## The Planning Inspectorate Yr Arolygiaeth Gynllunio

### **Application by AQUIND Ltd for the AQUIND Interconnector**

#### **The Examining Authority's first written questions**

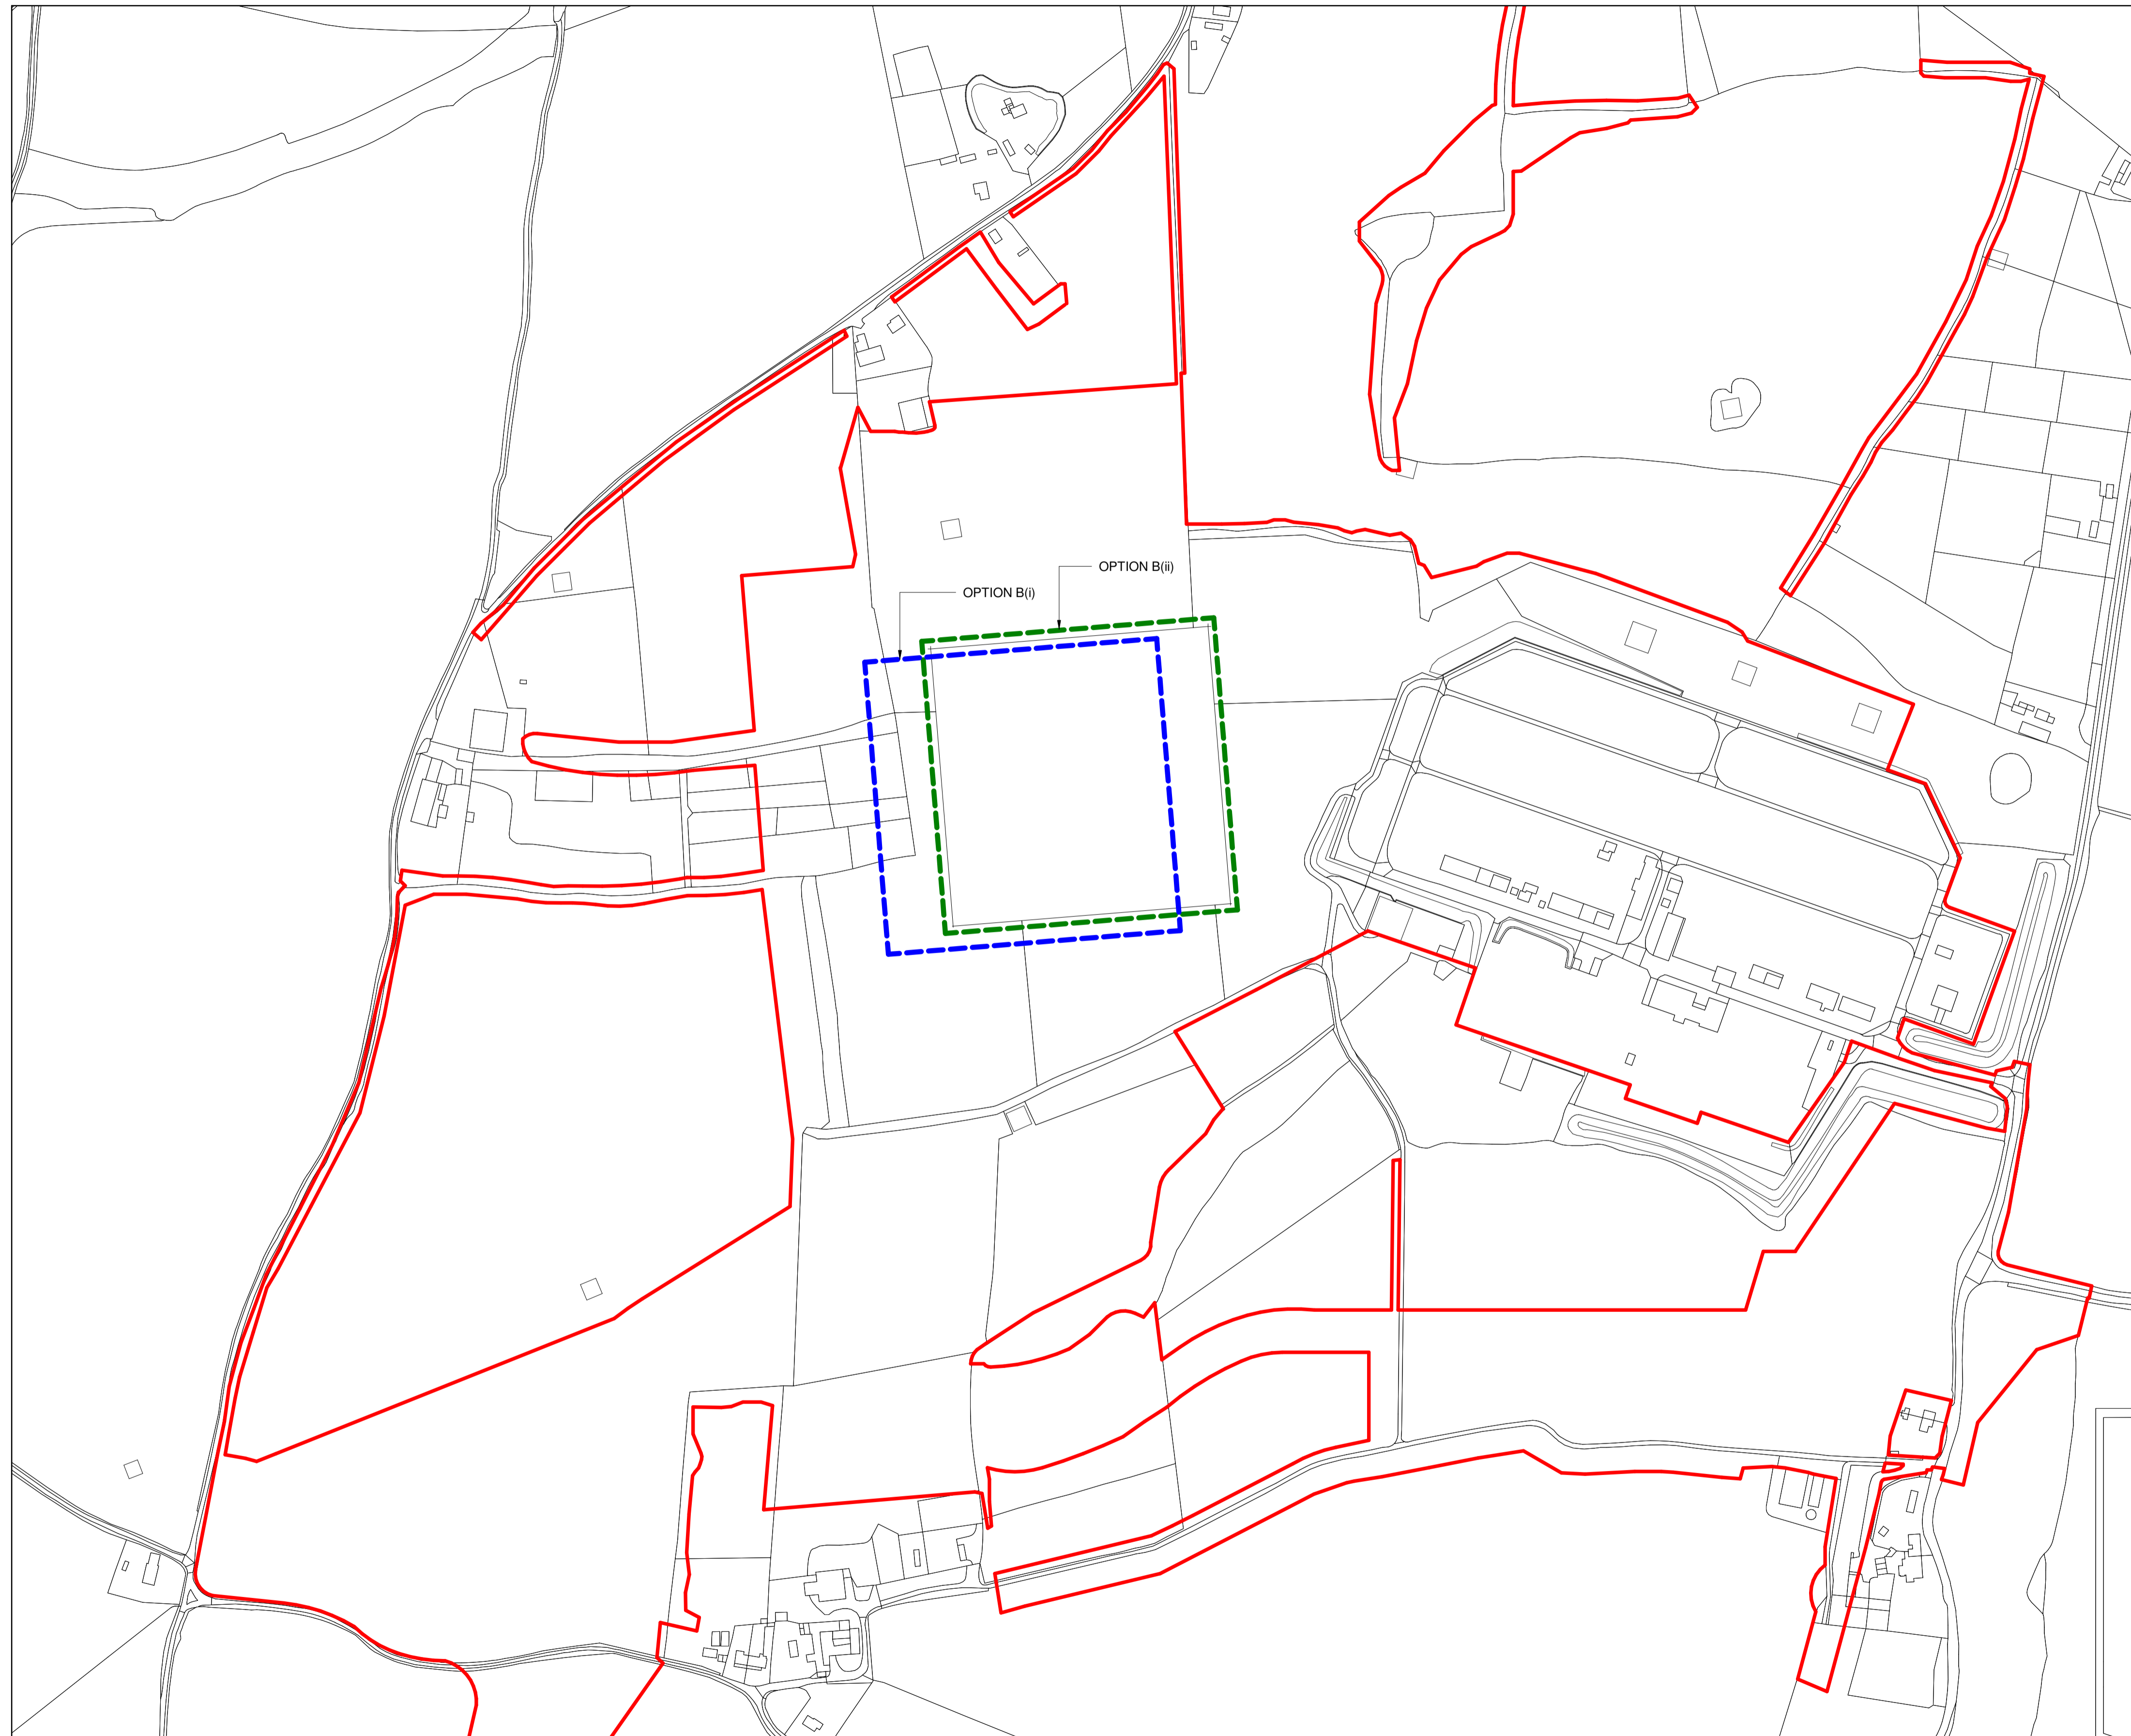
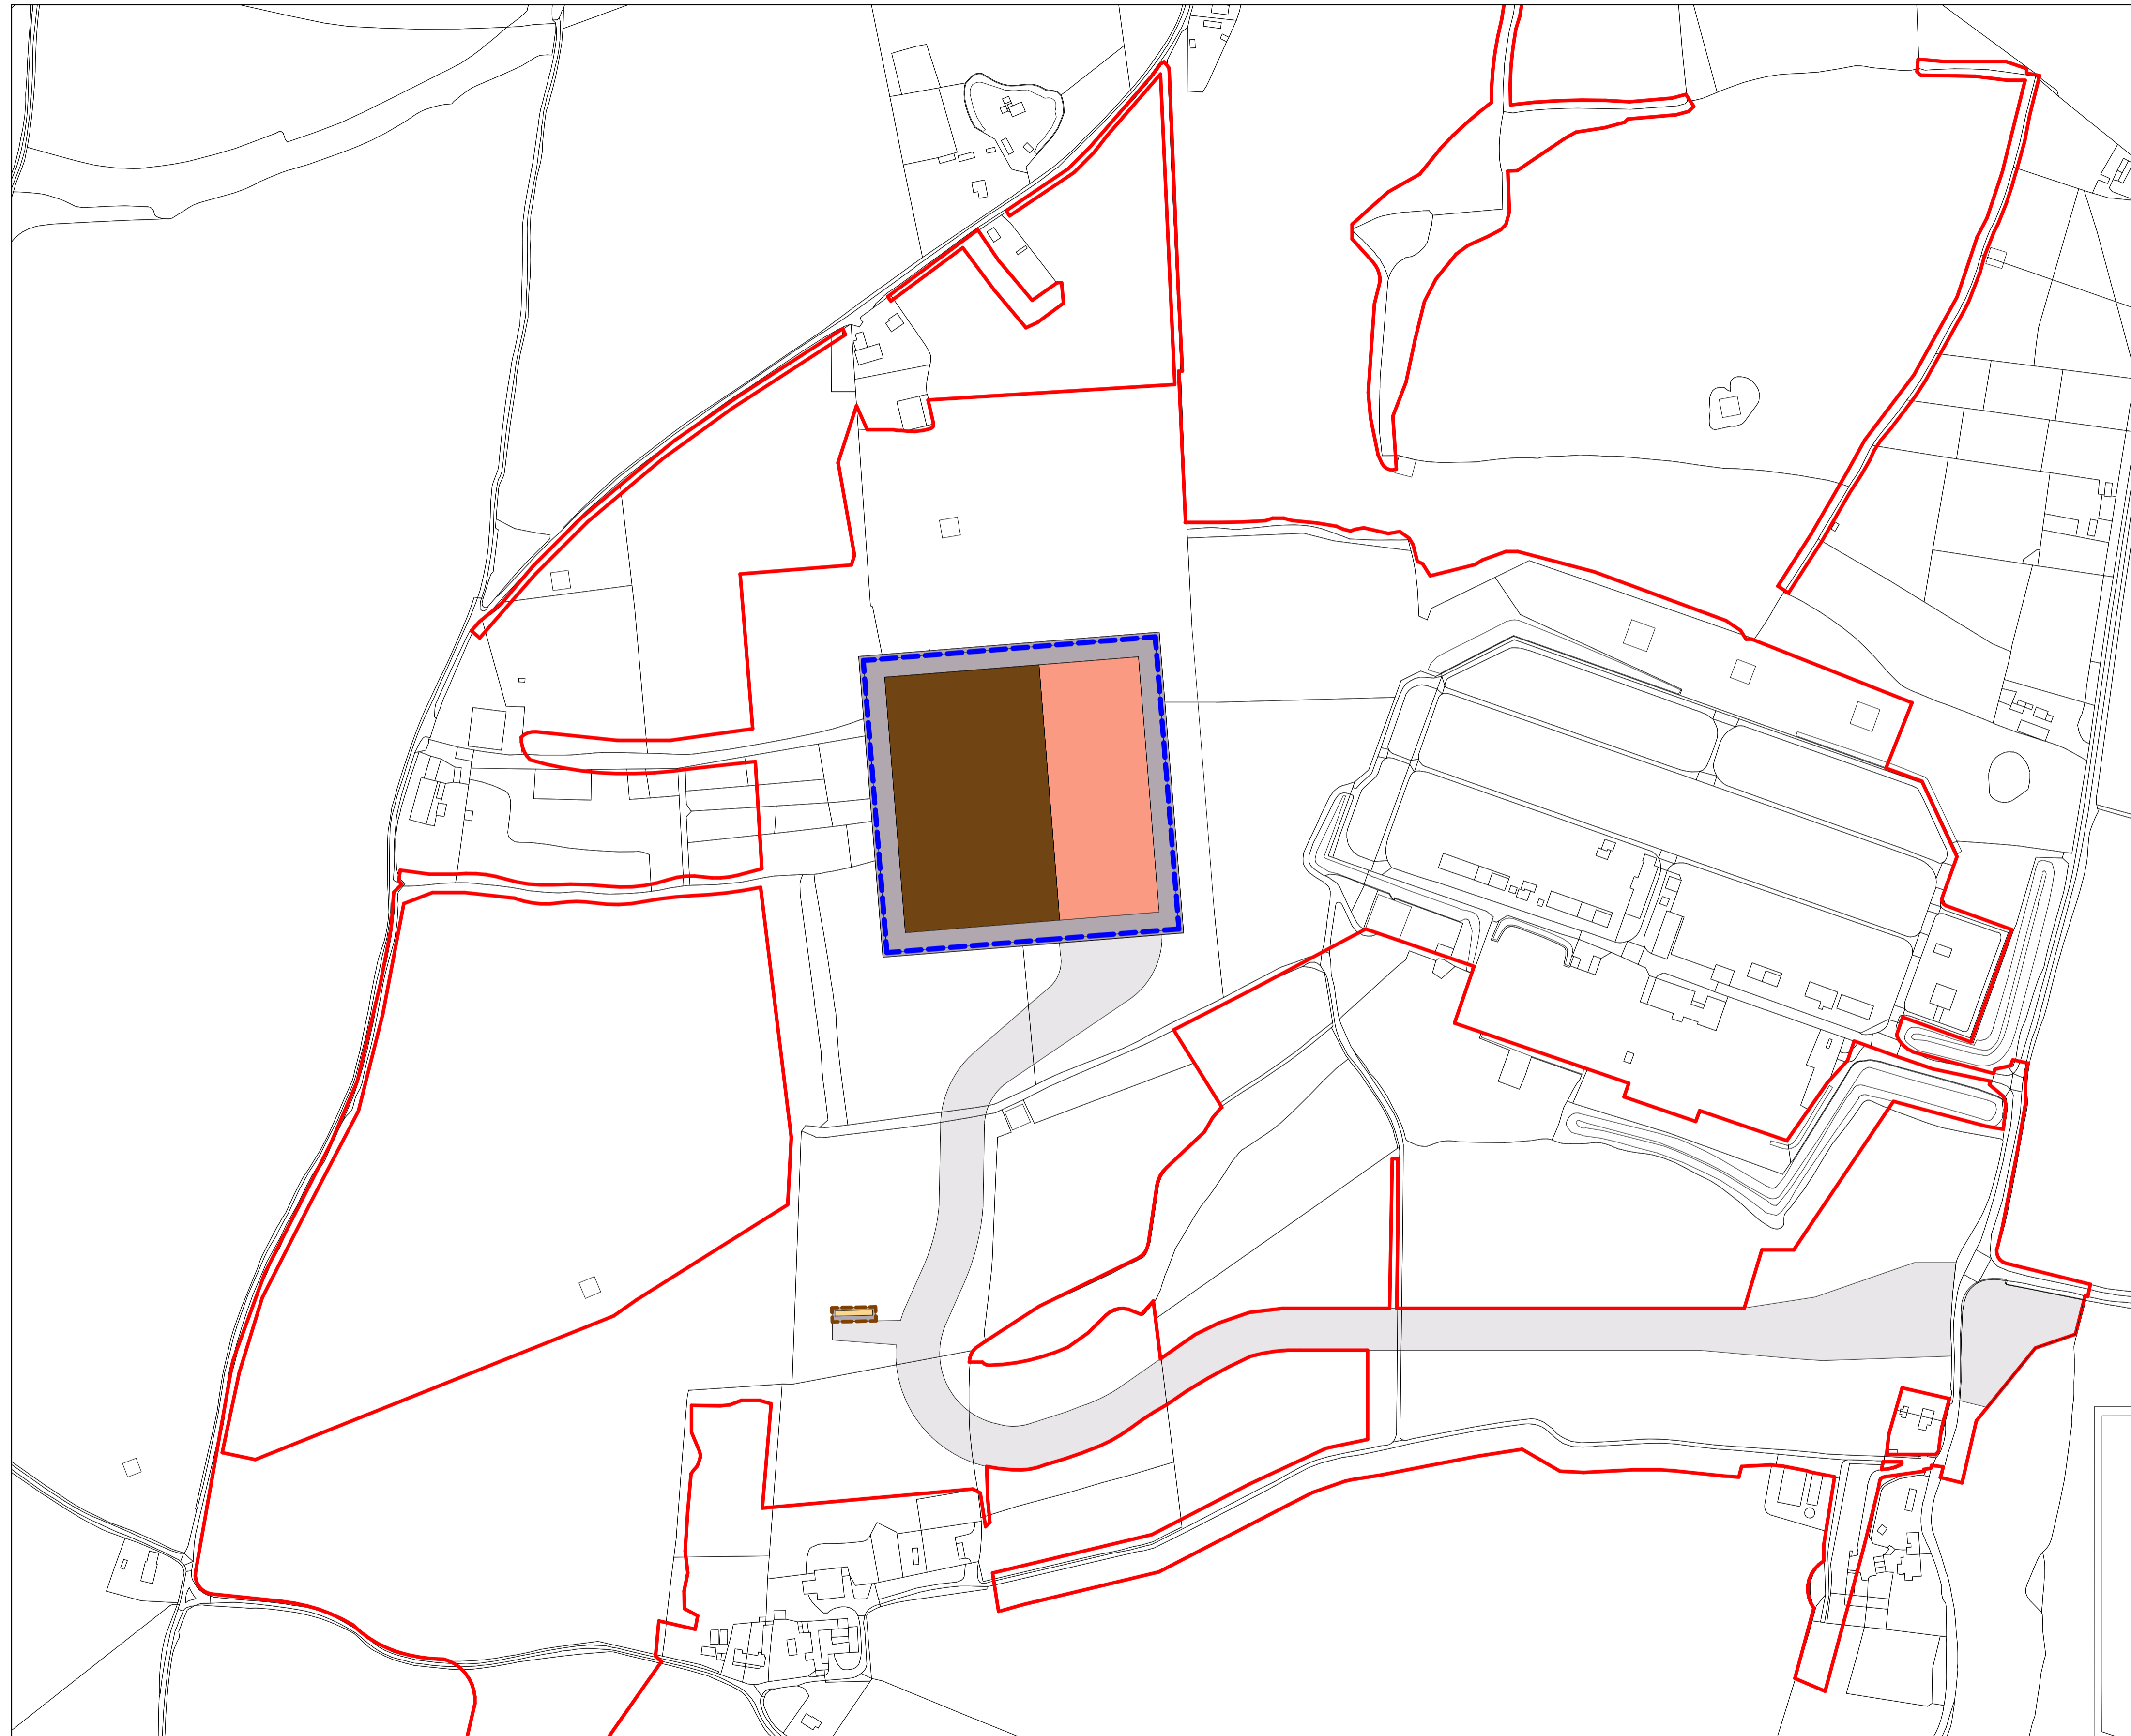
Reference	Respondent(s)	Question	Response By Winchester City Council
			attention focusing on the materials.
MG1.1.6	The Applicant	<p>Please describe how the final finished floor level for the Converter Station was arrived at, and how this is dealt with in the design principles and parameter plans and tables ([APP-012] and [APP-019]).</p> <p>Confirm that the EIA used the 'worst case' within the Rochdale envelope that is set for this, especially LVIA and in relation to impacts on groundwater.</p>	
MG1.1.7	The Applicant	<p>In the Onshore Outline CEMP [APP-505], there are numerous references to SINCS, but these do not seem to appear on the constraint maps in Appendix 1. Please can the Applicant clarify.</p>	
MG1.1.8	The Applicant	<p>In Table 2.1 of the Onshore Outline CEMP [APP-505], please could the Applicant explain why:</p> <ul style="list-style-type: none"> <li>• not all receptors addressed later in the document are included in this summary list (for example, hedgehogs and Wildlife and Countryside Act Schedule 9 plants);</li> <li>• '<i>semi-improved negligible and calcareous grassland</i>' appears twice in the onshore ecology entry: and please clarify what is meant here by 'negligible';</li> <li>• the list in the heritage and archaeology entry is restricted to below-ground archaeological assets and excludes built heritage assets.</li> </ul>
